Accessibility Design Review Report

Project Title: **Compass 2 Warehouse and Distribution Centre
Lot 1 Eastern Creek Drive, Eastern Creek**

Date: **09 February 2022**

Report Version: **21497_ADR_SSDA_v1.2**

1 SITE PLAN

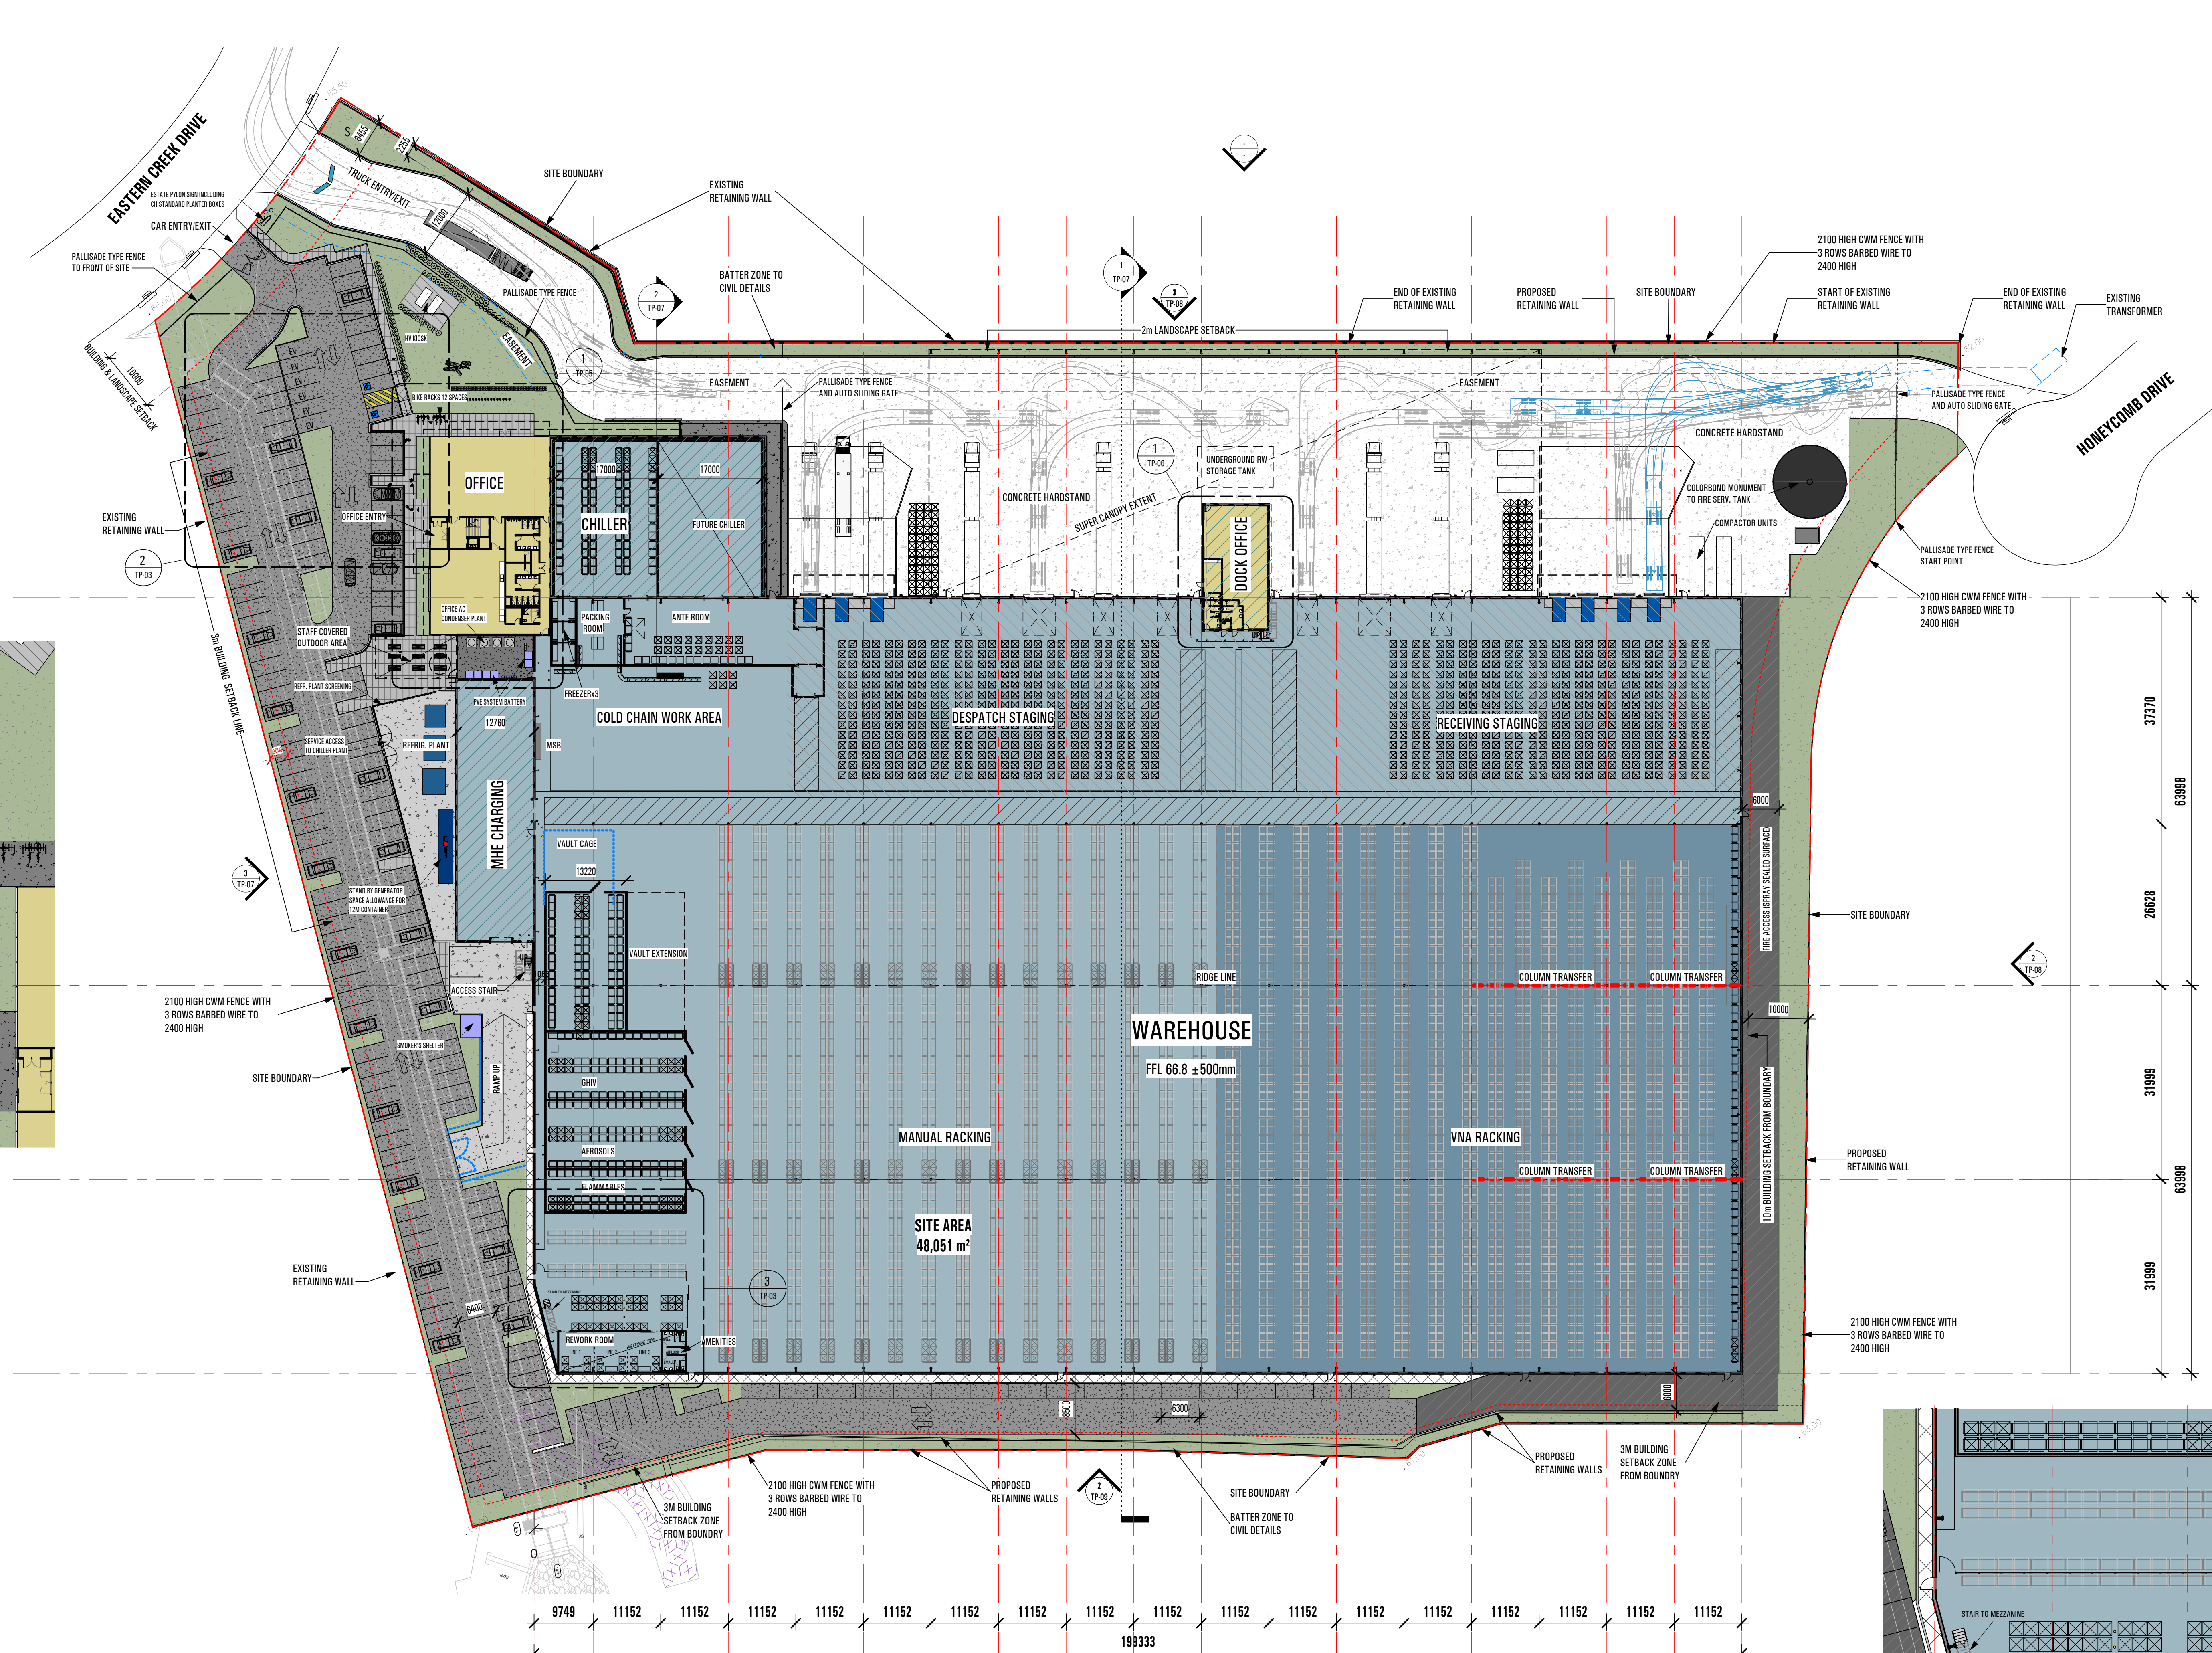
Accessible parking is proposed adjacent the office building entry. Kerb/step ramps appears to be proposed as the parking is not on the same grade as the footpath.

SHEET NAME: OFFICE PLANS SHT 1	
JOB NO. 4387-21	SCALE: 1 : 100
Drawing No: TP-05	ISSUE DATE: 3/02/2022
REVISION: B	DRAWN BY: FF

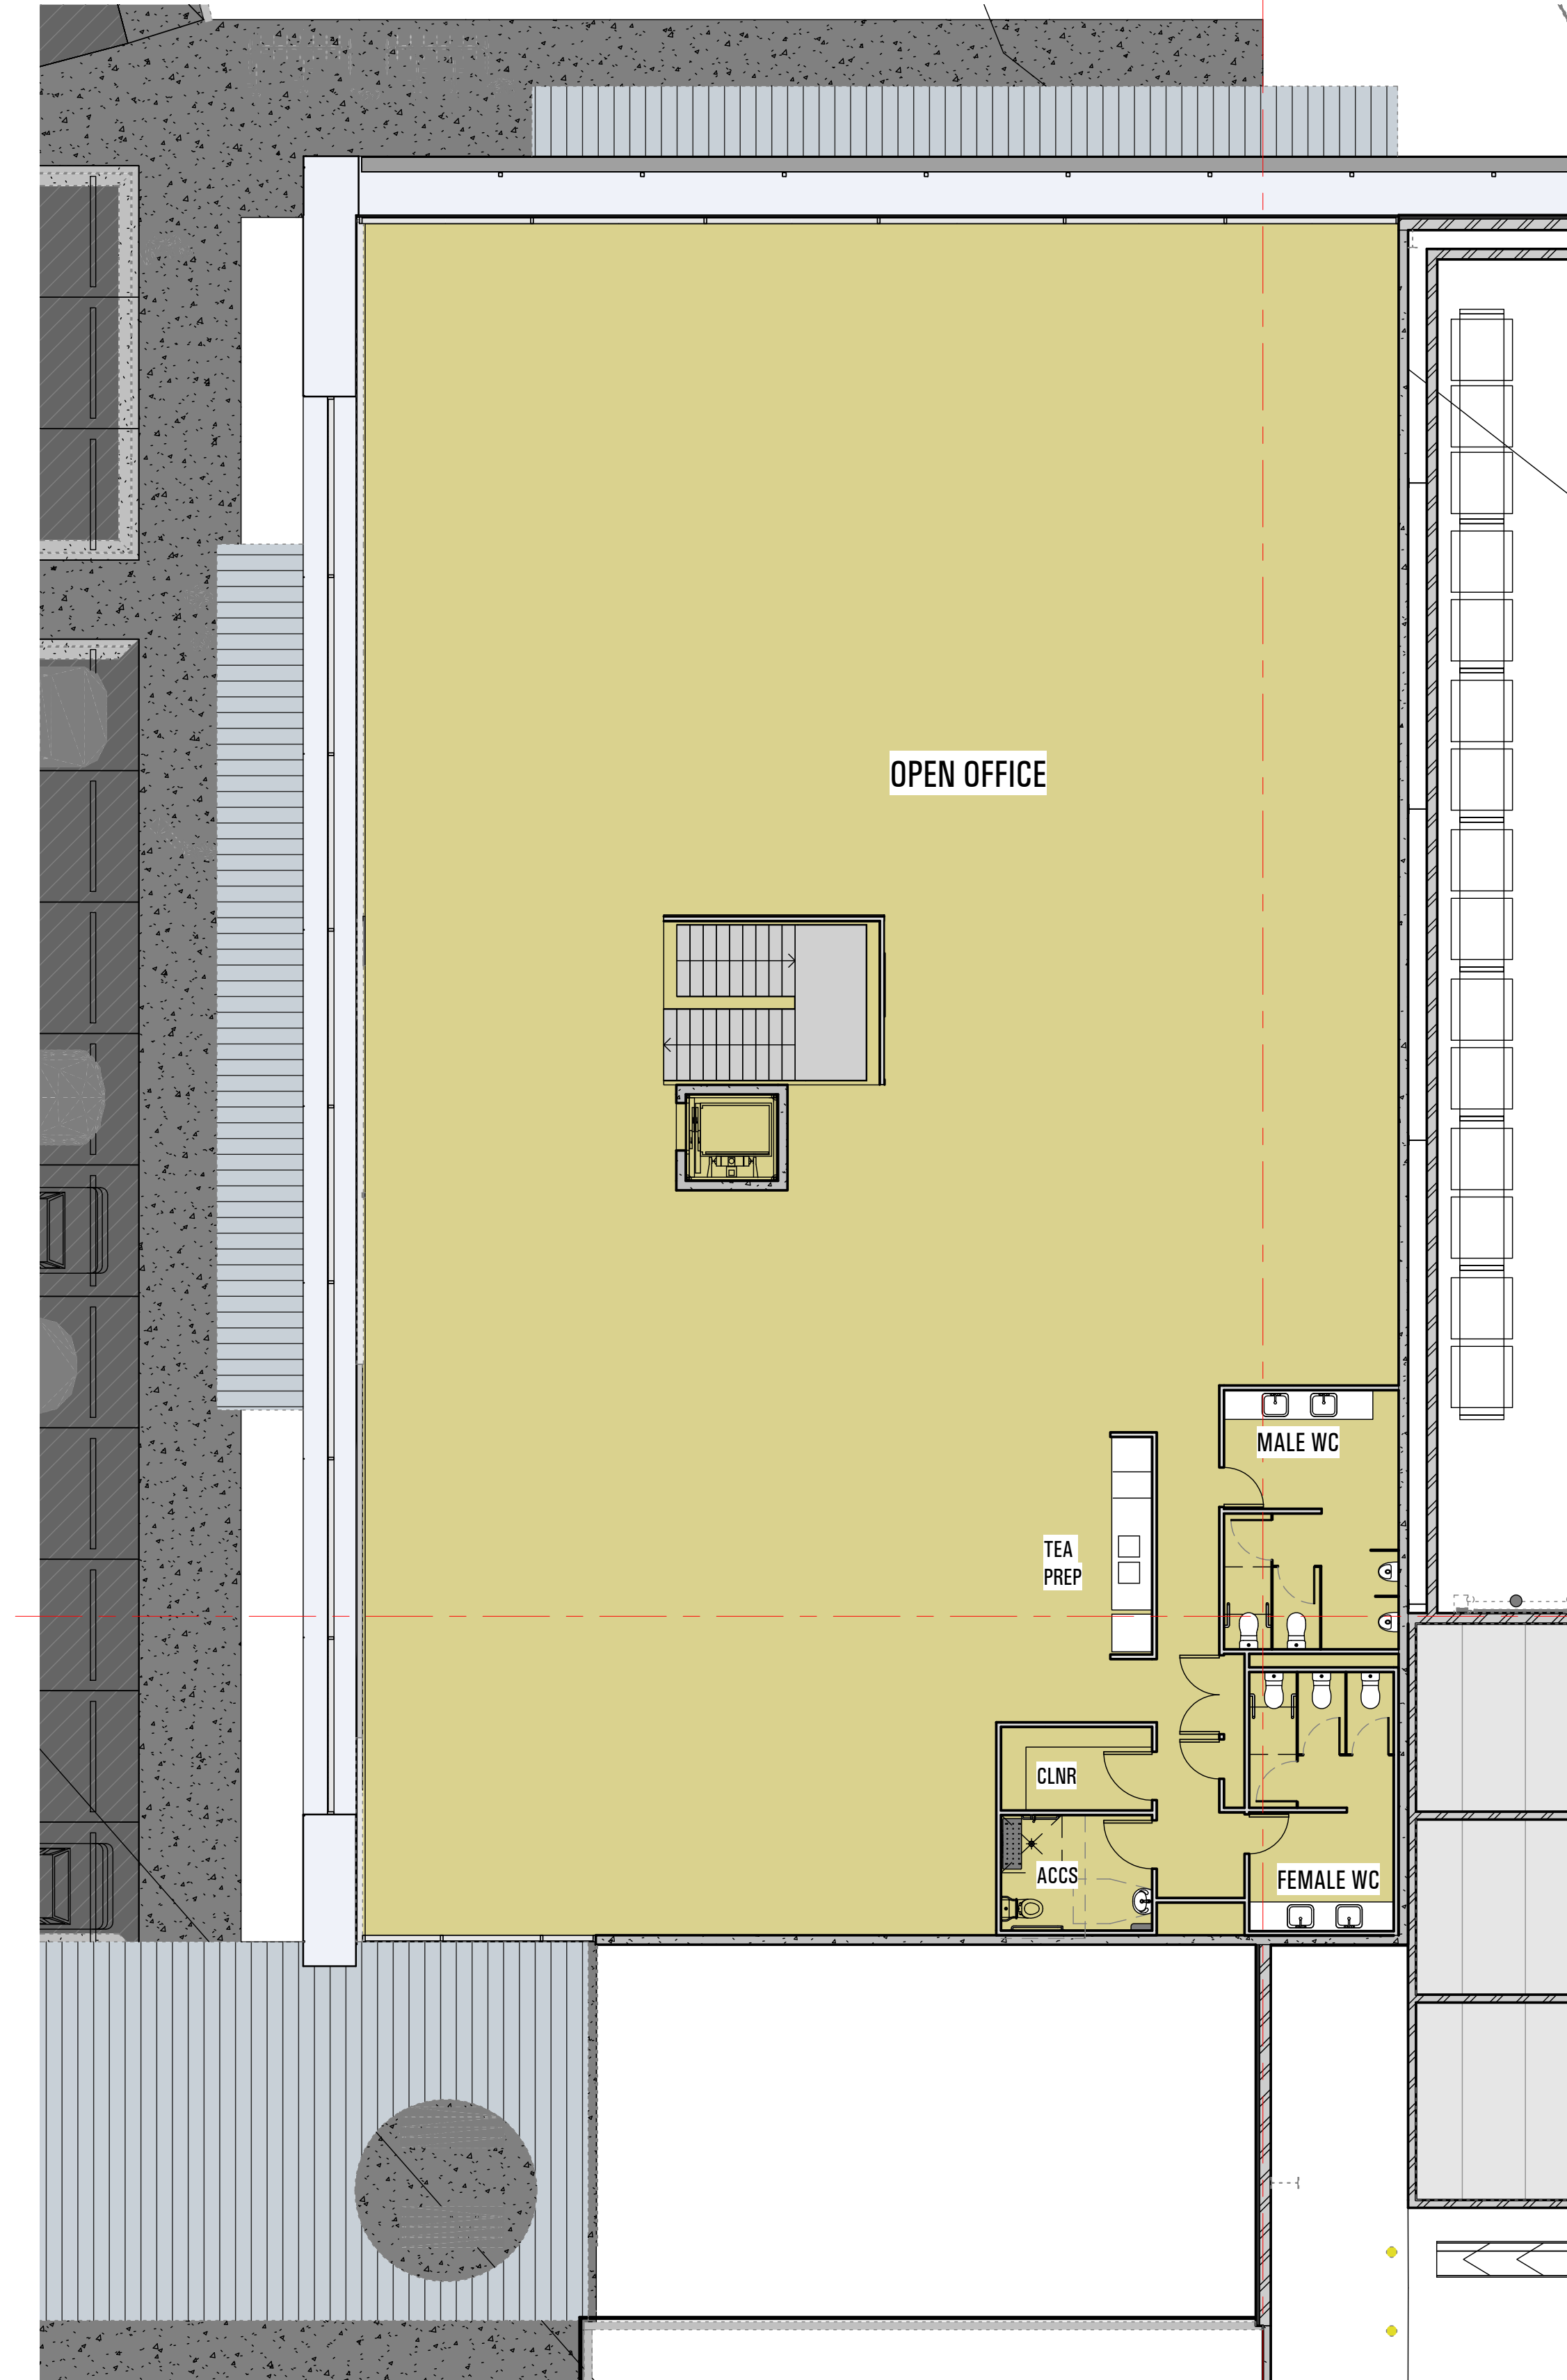
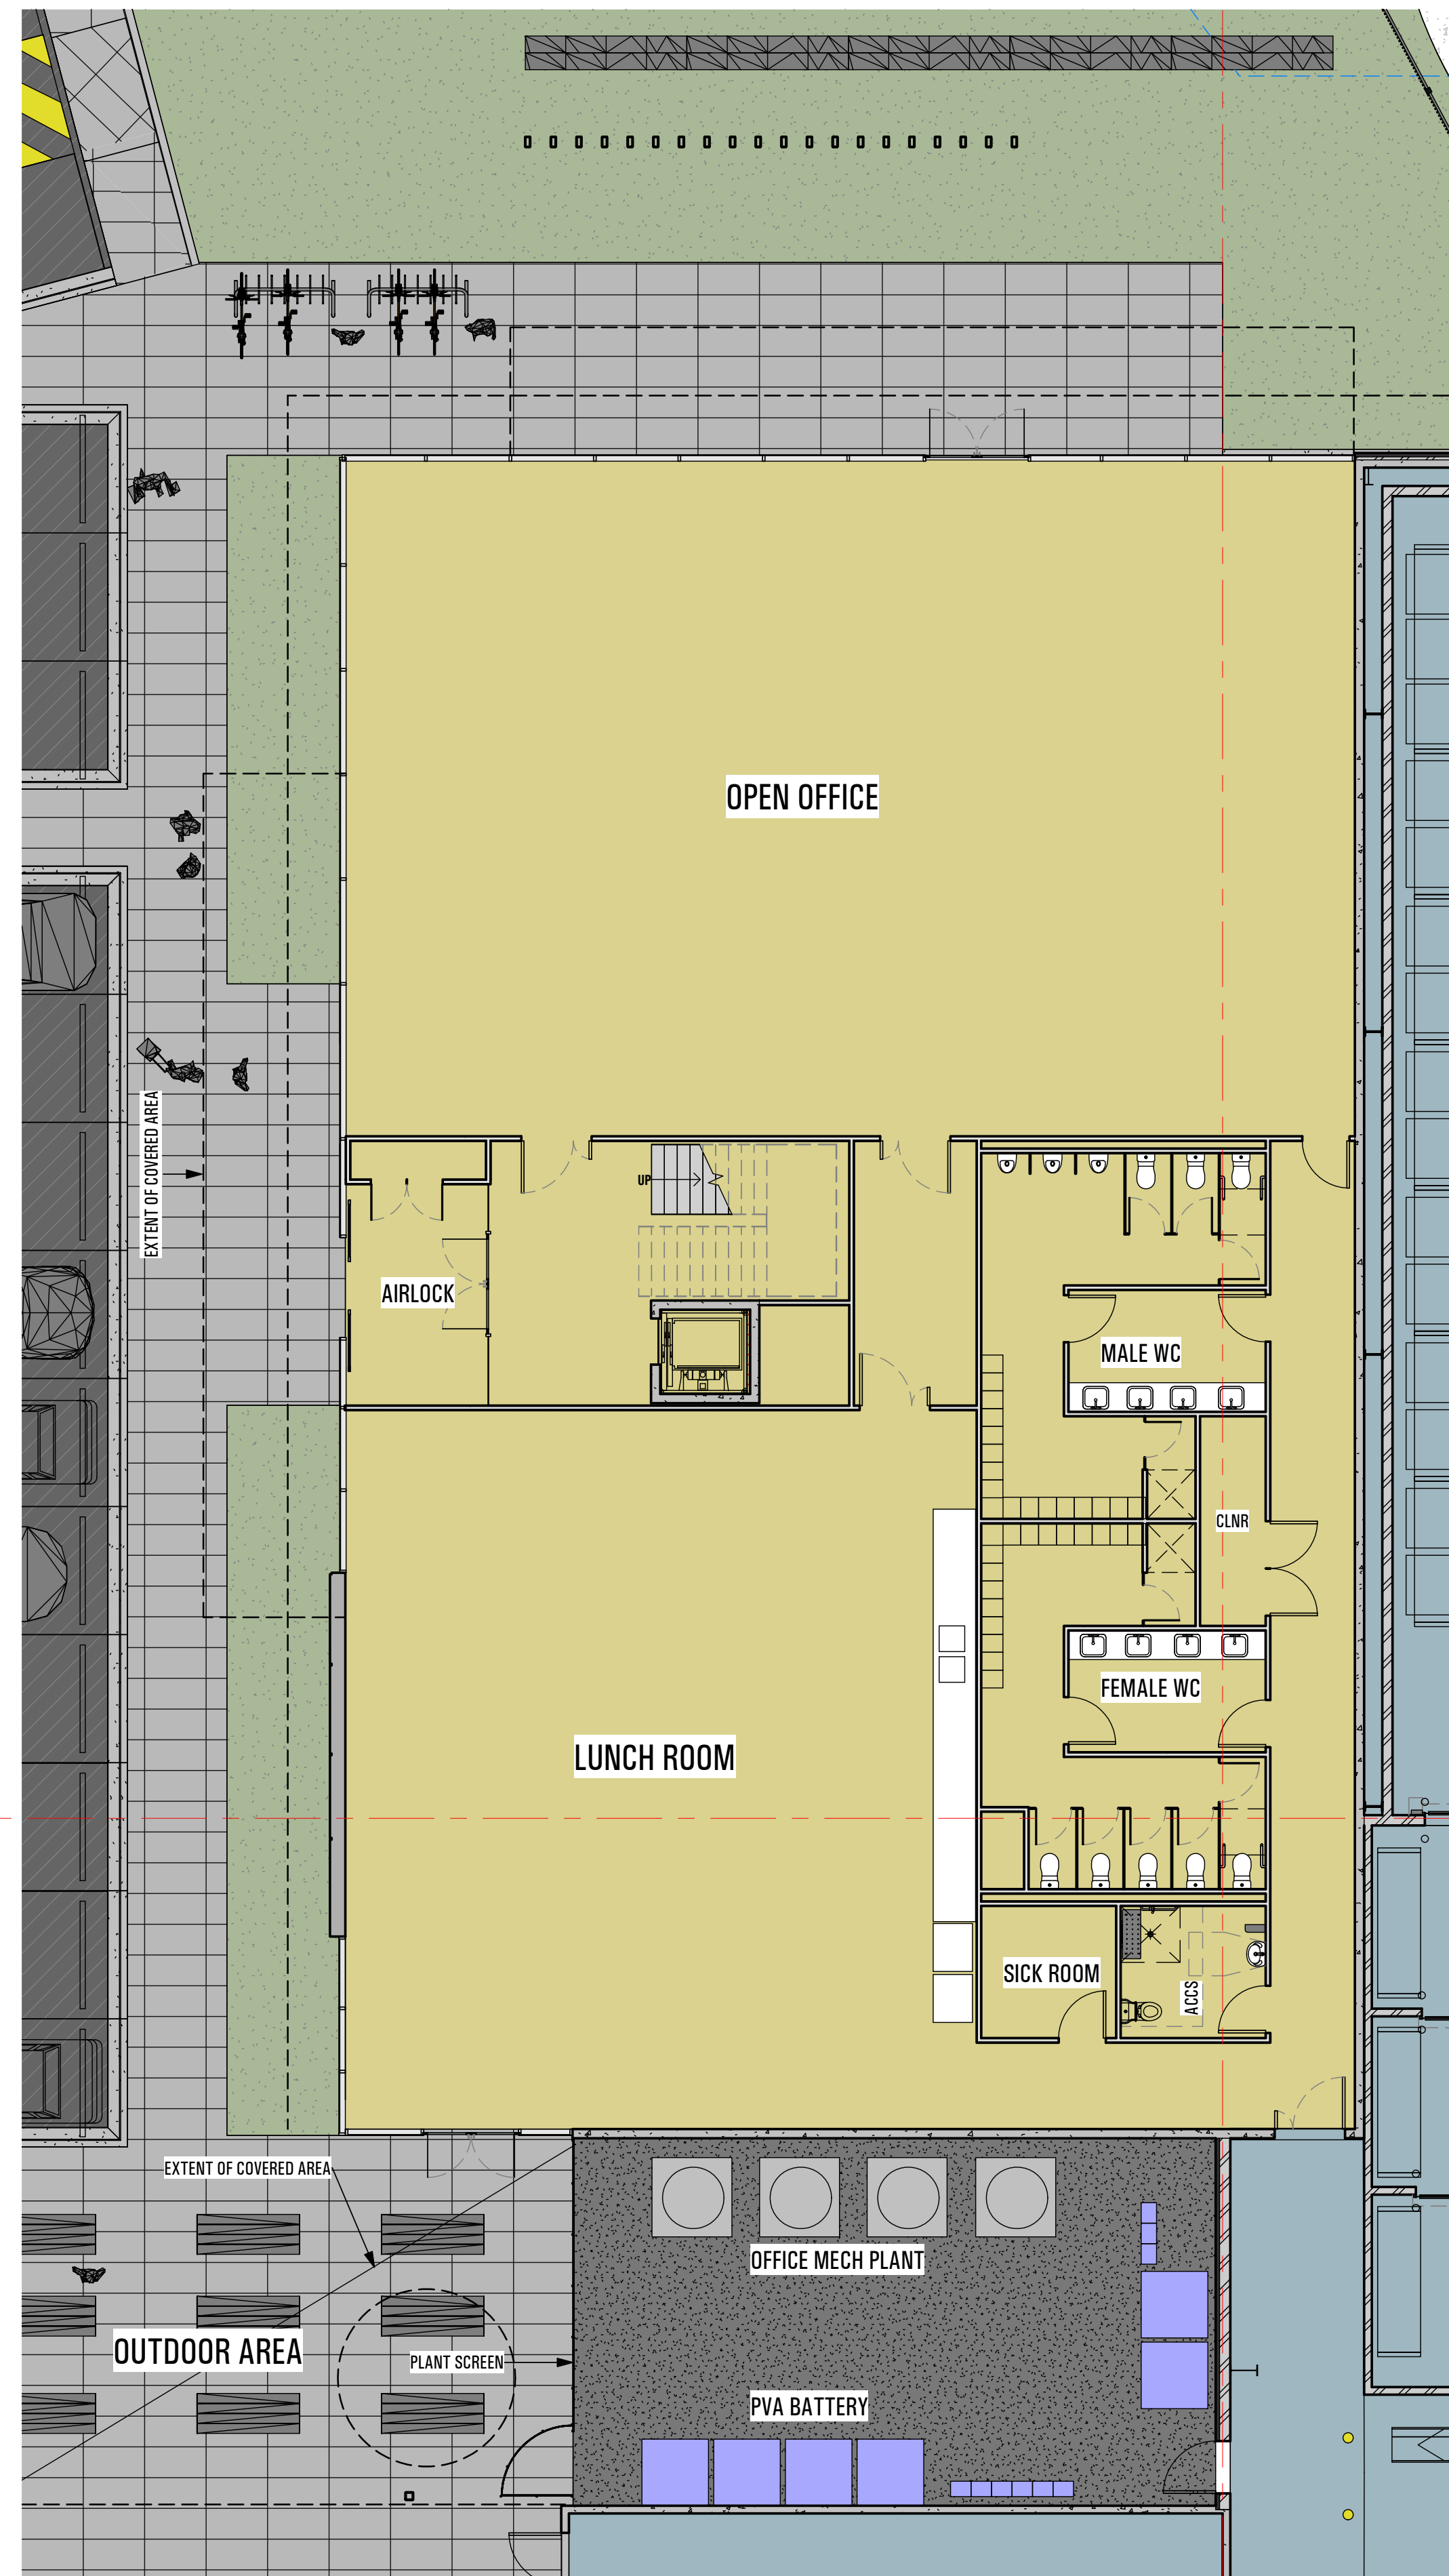
Minimum 1220mm circulation space for a predominantly side-on approach is required to the external side of the first-floor accessible unisex sanitary facility doorway.
